Subject: RE: Y/19/22/DOC Approval of details condition 4 under Y/89/14/PL ref PRow

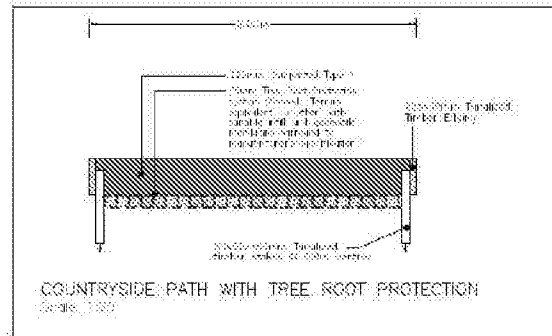
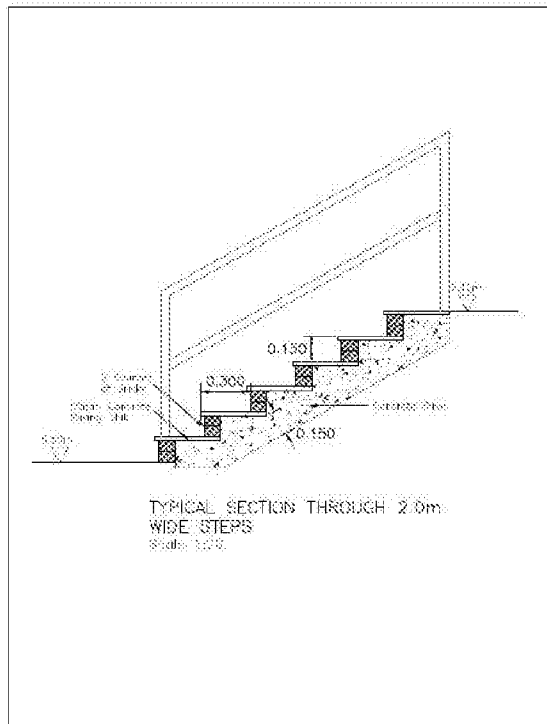
Thank you for your email. The proposed spec for the Countryside footpath is on the submitted plan, screenshot below, is the Officer advising this is not sufficient detail or have they missed this note?

I can confirm the feature that the Officer advises may be a road are actually power lines.
